Wise Engineering
3915 Old Fairground Rd.
Angier, NC 27501
(919)894-2203

Subject: 179 Azalea Dr., Spring Lake, NC 28390

At your request, a representative from Wise Engineering (WE) reviewed the home located at 179 Azalea Dr, Spring Lake, NC 28390. Specifically, we reviewed the below items outlined in the home inspection report by A Pro Edge Home Inspections dated April 12, 2024. All views as if you are standing on Azalea Dr., facing the front of the home.

179 Azalea
Spring Lake, NC
4-24-24

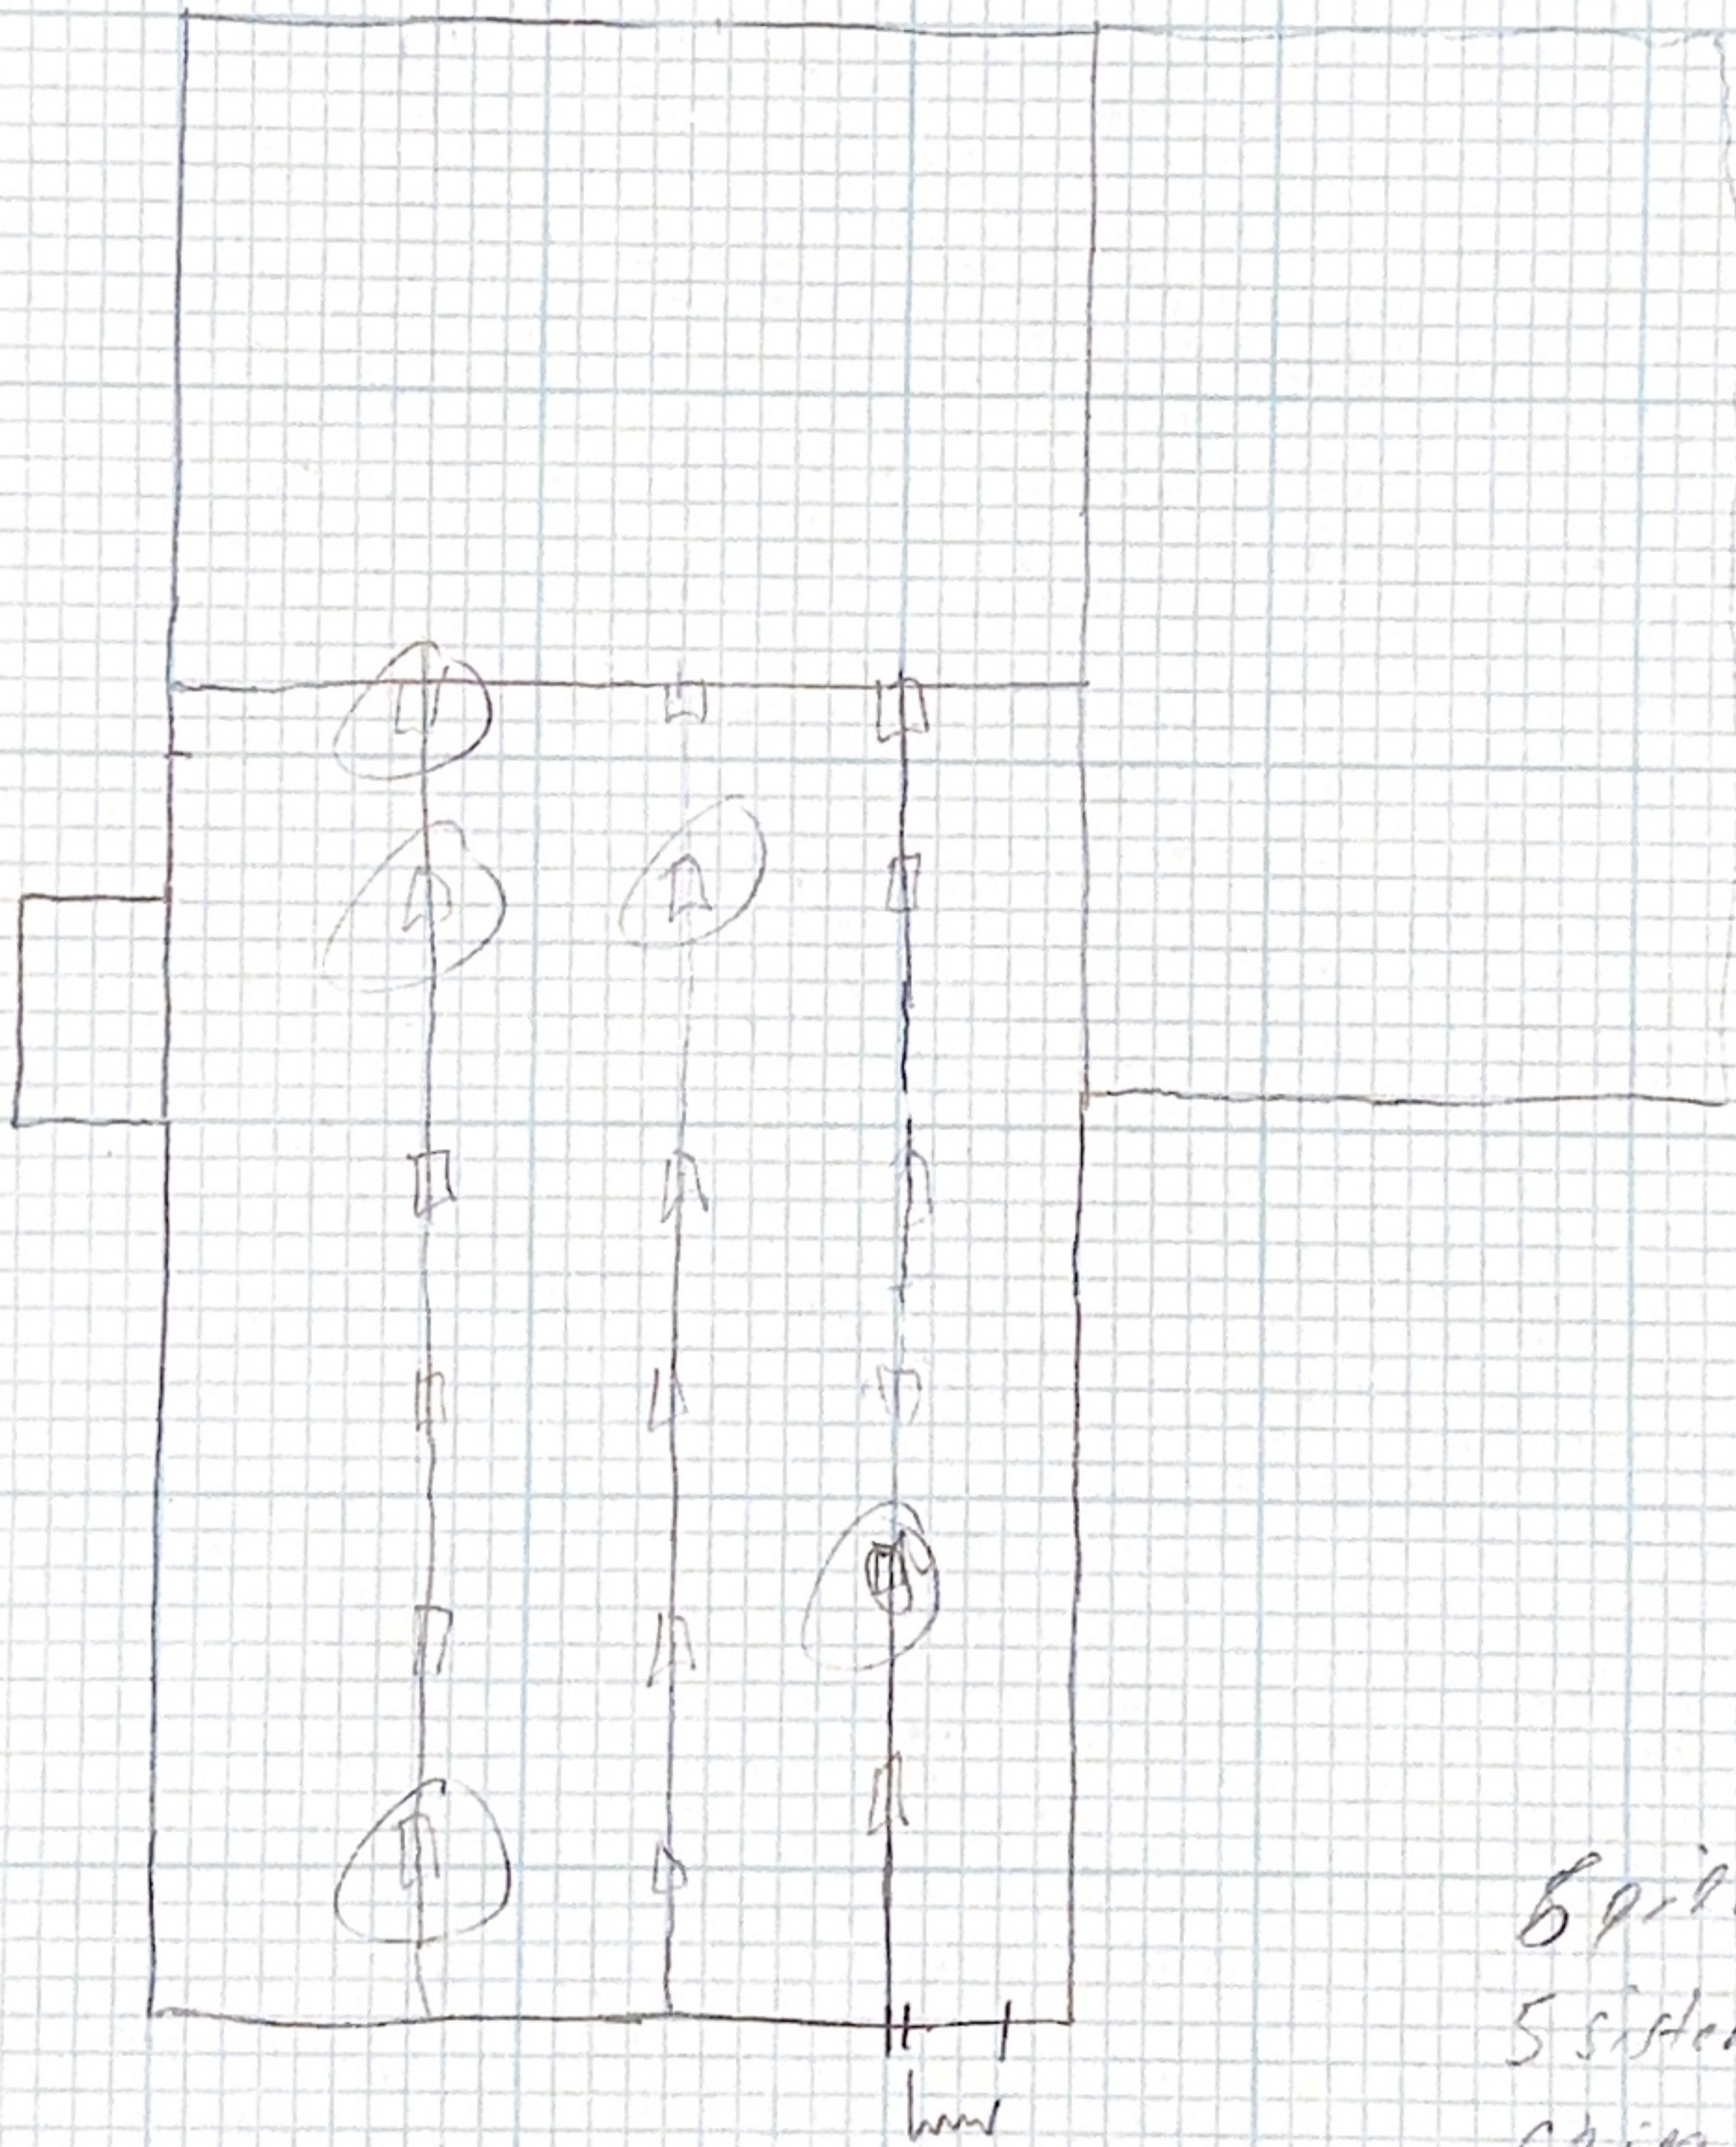
4. There are multiple piers that require repair and/or replacement.
 - The first pier is located in the right rear of the home and has settled approximately 1" below the girder above. During our inspection, we were unable to locate a concrete footing beneath the masonry pier. WE recommends removing the existing pier and installing a new 8"x16" masonry pier centered on a 24"x24"x8" concrete footing. The footing should bear on soil that has a minimum bearing capacity of 2000PSF.

- The next two piers are located on the far left side of the home within the pier and curtain foundation wall. The piers have settled and are no longer providing support to the dropped girders. WE recommends removing and replacing the piers with a new 8"x16" masonry pier centered on a 24"x24"x8" concrete footing or installing a deep foundation stabilizer beneath the piers and shimming the gap between the piers and the dropped girder.

- There are two additional piers on the left side of the home that the upper half of the piers have been altered. WE recommends removing the damaged section of the piers and installing new masonry on top of them such that there is a maximum of 3" of wood shims between the top of the pier and the existing dropped girder.

5. At the right front of the home there is a pier that is leaning and the mortar joints have been compromised. WE recommends removing the existing pier and installing a new 8"x16" masonry pier centered on a 24"x24"x8" concrete footing.

7. The floor joists under the guest bathroom tub should be sistered from bearing point to bearing point instead of scabbed in short sections. Additionally, any repairs to the subfloor above should have edge bearing at the midpoint of 2x blocking that is properly secured to the floor joists.
